**RE: SUBMISSION TO SSD-78996460 16-24 LORD STREET & 21-27 ROSEVILLE AVENUE, ROSEVILLE**

Thank you for the opportunity to comment on Response to Submissions (RtS) for State Significant Development (SSD) Application (SSD-78996460) for a residential flat building with affordable housing at 16-24 Lord Street & 21-27 Roseville Avenue, Roseville.

**Team Leader Development Assessment**  
***Attachment 1 – Response to Submissions Table***

Figure 4 Proposed sections

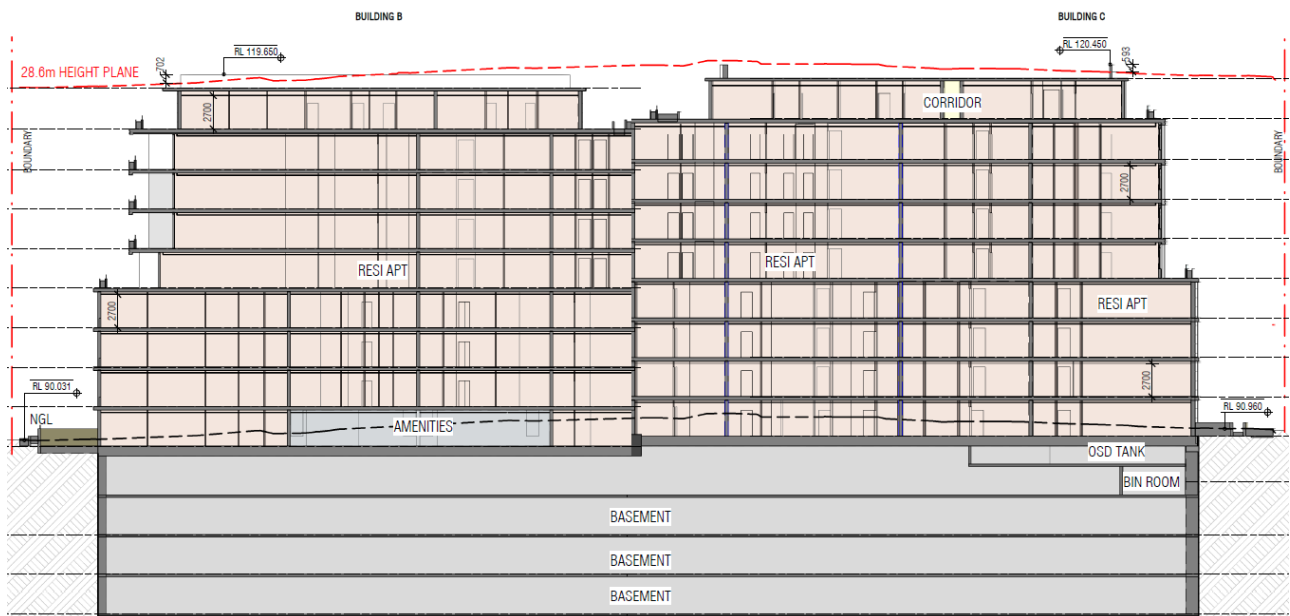
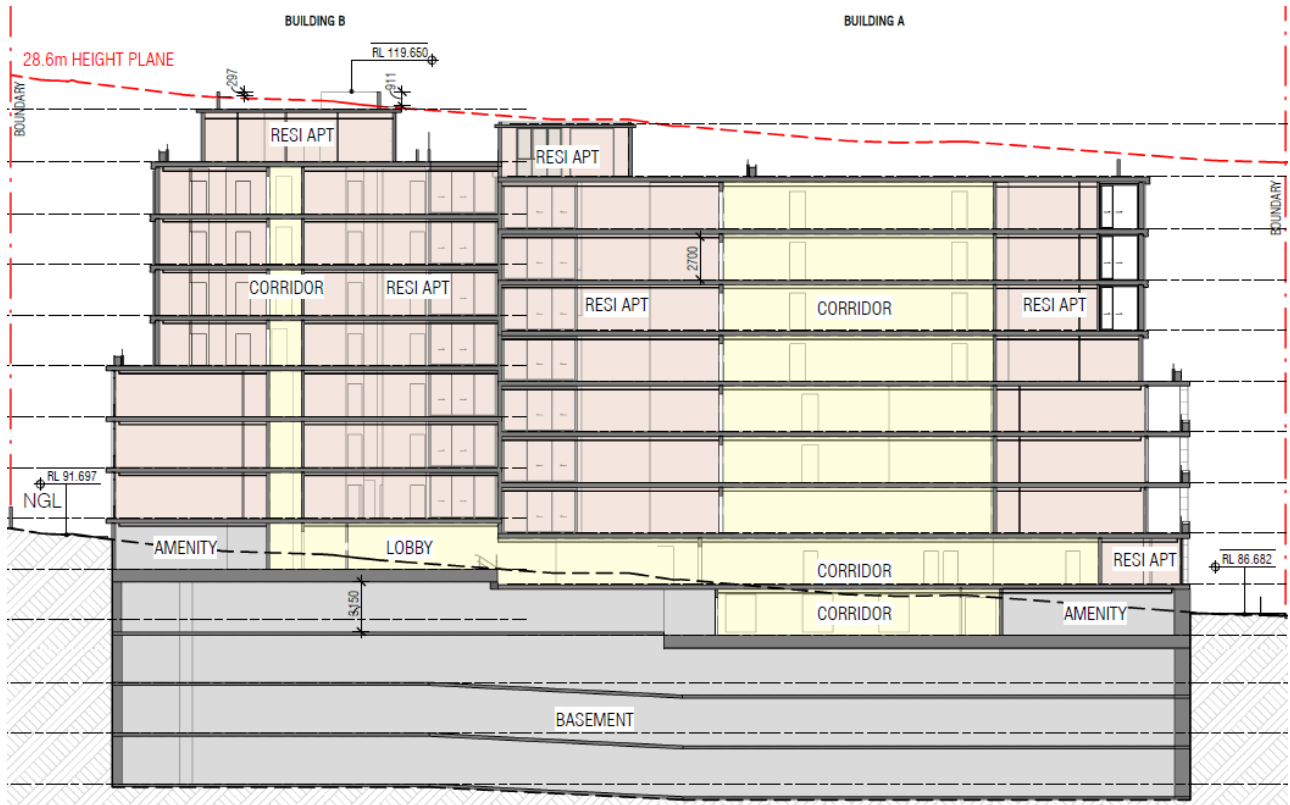
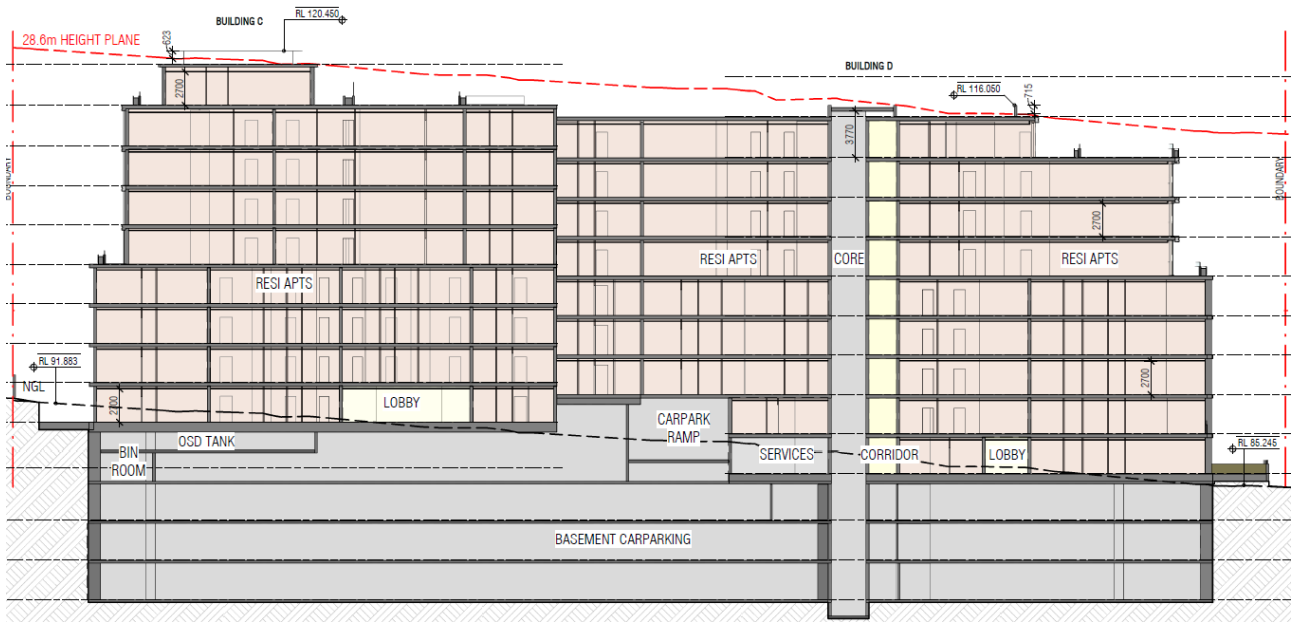
<p><b>5 Building Height</b></p>	
<p>The developments HoB was difficult to confirm due to missing information.</p>	<p><b>Matter Resolved</b></p> <p>It's noted that the applicant has reduced the overall building height reducing the buildings height exceedance at its worst to 1.07m. The applicant has also updated its plans with levels from the survey to confirm the point of which height of building is measured.</p>
<p>Clause 4.6 request is not well founded.</p>	<p><b>Matter for DPHI to be satisfied off.</b></p> <p>Council maintains that there are insufficient environmental planning grounds to justify the breach of the development standard. The developments height breach is exacerbated by the developments non-compliance with key development controls such as setbacks, built upon area and heritage controls.</p> <p>The cumulative effect of not complying with numerous planning controls indicated that there are insufficient environmental planning grounds to justify that exceedance to HOB is unreasonable and unnecessary.</p> <p>As noted below, whilst there remains a height breach, this height breach is not well-founded as the applicant bulk and scale has not been reduced. This is a result of the applicant sinking the built form underground, rather than making any meaningful positive reductions to building height. As such it results in built form that remains uncharacteristic of the area and ad's additional environmental impacts through excessive excavation and uncharacteristic elements (exposed basement walls and additional retaining walls) now introduced into the HCA.</p> <p><u>Additional Comment</u></p> <p>Upon review of the applicants revised plans whilst the HoB has technically decreased in accordance with the definition under the standard instrument, this height reduction <b>is technical only</b>. The applicant has effectively sunk the entire building below ground to reduce height, rather than make meaningful height reductions.</p> <p>Council is concerned with the excessing additional excavation now associated with the development, including the sinking of the majority of the ground floor under ground. This design move is inconsistent with the low-density character and results in additional impacts such as:</p> <ul style="list-style-type: none"> <li>• Exposed basement walls (1.9m in height) which are incompatible with the surrounding environment and create a harsh interface with the adjoining heritage item, detracting from its significance.</li> <li>• Excessive excavation results in more retaining wall structures interfacing the public domain, that are destructive to the local character.</li> <li>• Amenity of occupants is reduced as residential lobbies are sunk below ground.</li> <li>• Additional impacts on trees now results from the building being sunk.</li> </ul>

At human scale, the Applicants design move of sinking the building does not assist in any perceivable reduction to bulk and scale. Council recommends that DPHI seek the applicant revise their design to remove exposed basement walls, and make meaningful amendments to their building height, that don't involve sinking the development further underground.
